From: Nia Russell [REDACTED]
Sent: 23 October 2017 11:52
To: Michael Eastham
Cc: Arfon Hughes
Subject: Fwd: Saltbox, Bognor Regis - Heads of Terms

From: karen jenkins [REDACTED]
Subject: RE: Saltbox, Bognor Regis - Heads of Terms
Date: 23 October 2017 at 11:04:11 BST
To: Arfon Hughes [REDACTED]
Cc: Nia Russell [REDACTED] Reg Kirk [REDACTED]

In Nia's absence, there are just two design details that have arisen regarding the Unit 2 Warehouse:

2A: With Acoustic Barrier L_{Aeq}

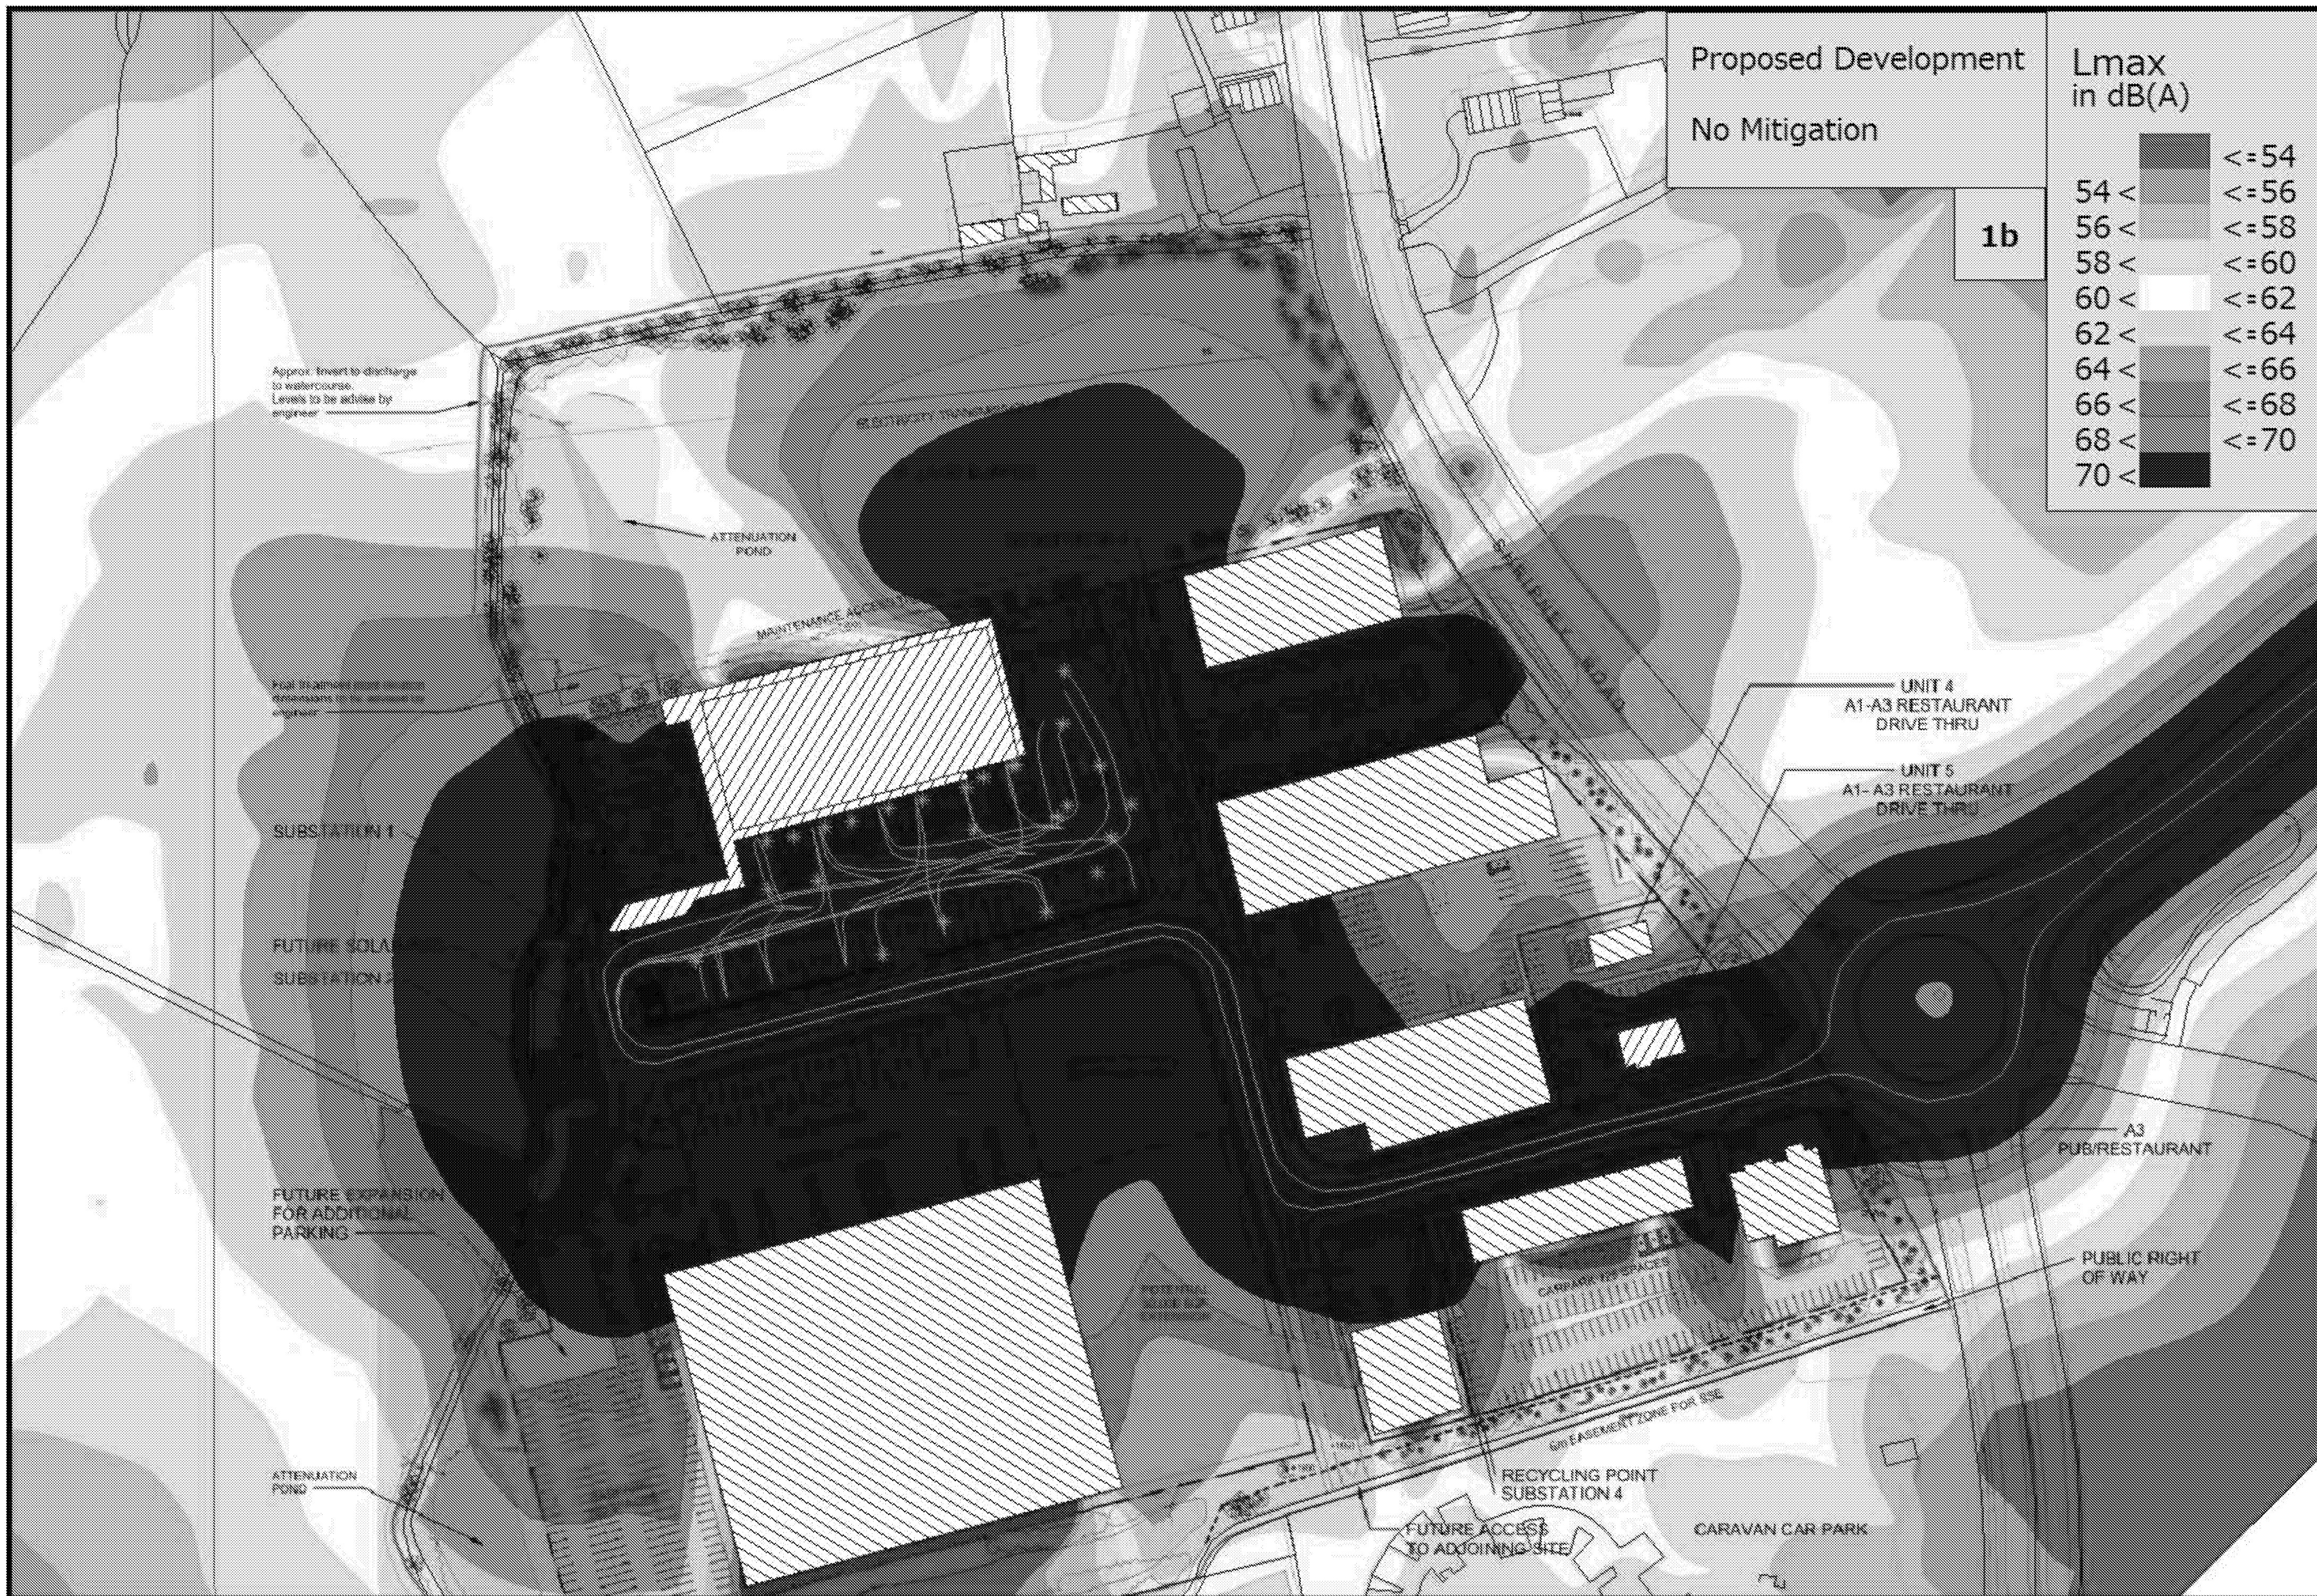
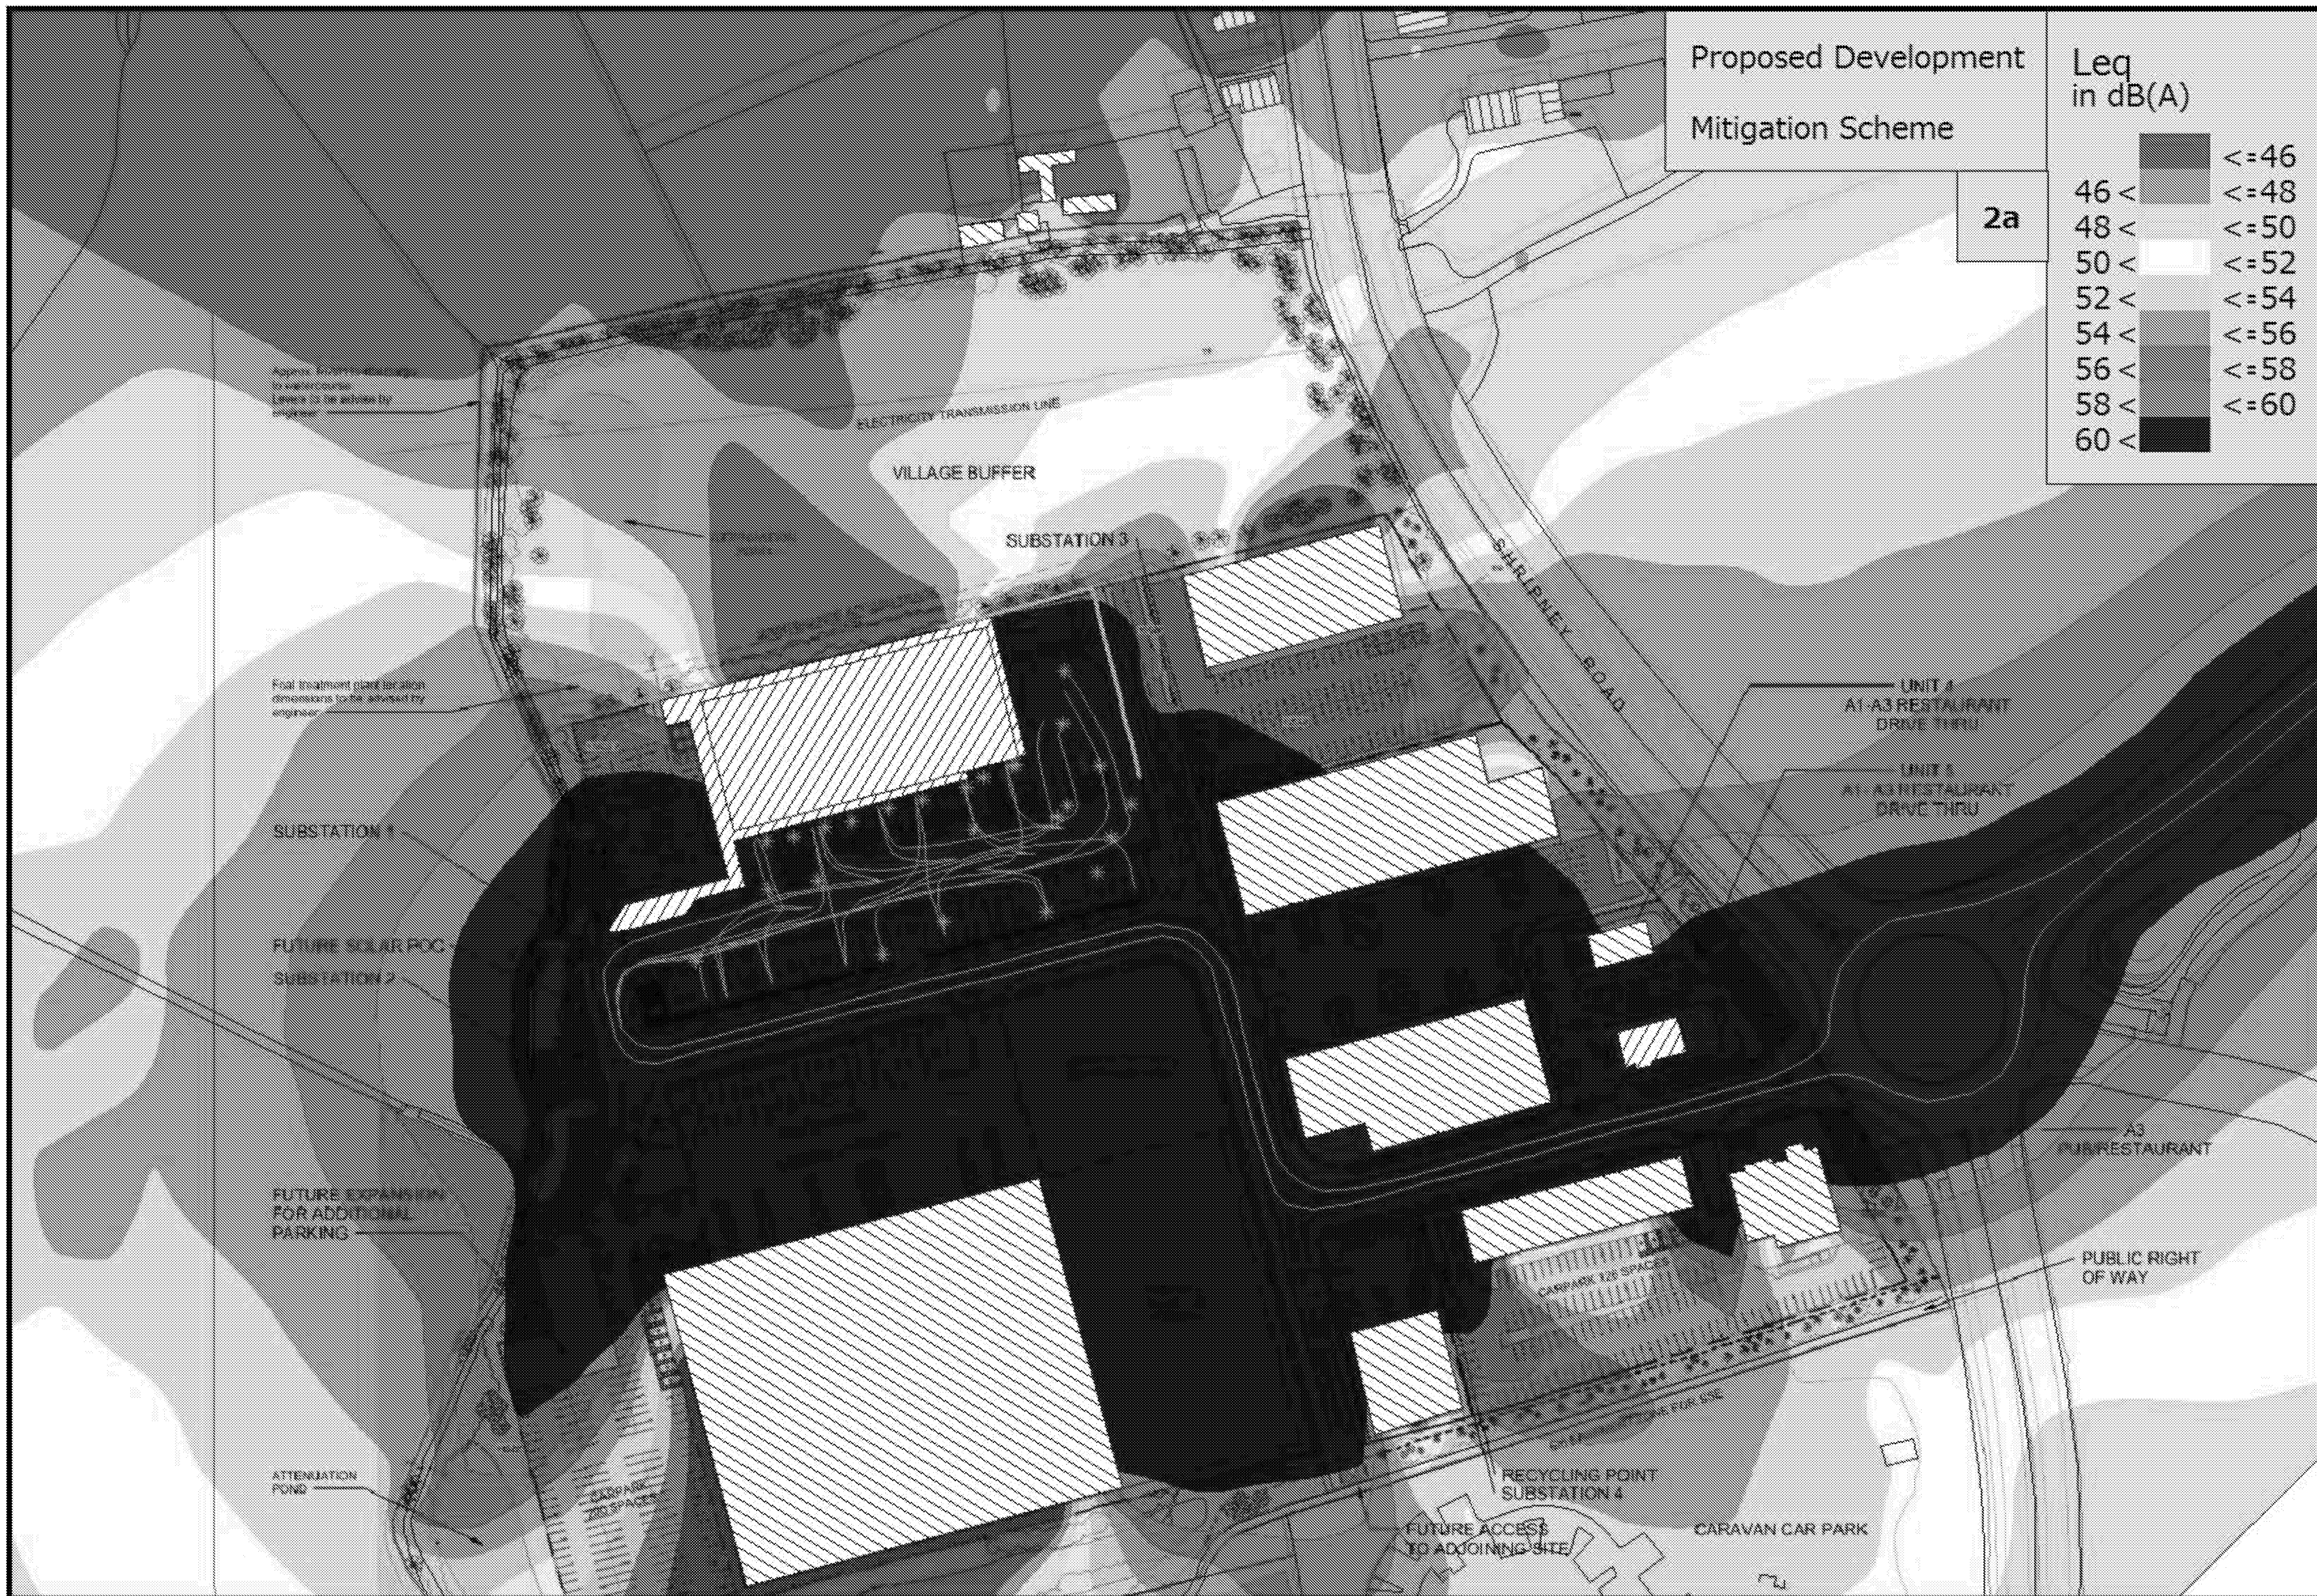
- 1) Does the Unit need to have security fencing (and gates) around it?
- 2) Does the acoustic fencing need to be 4.0 metres high? Could it be lower in height?
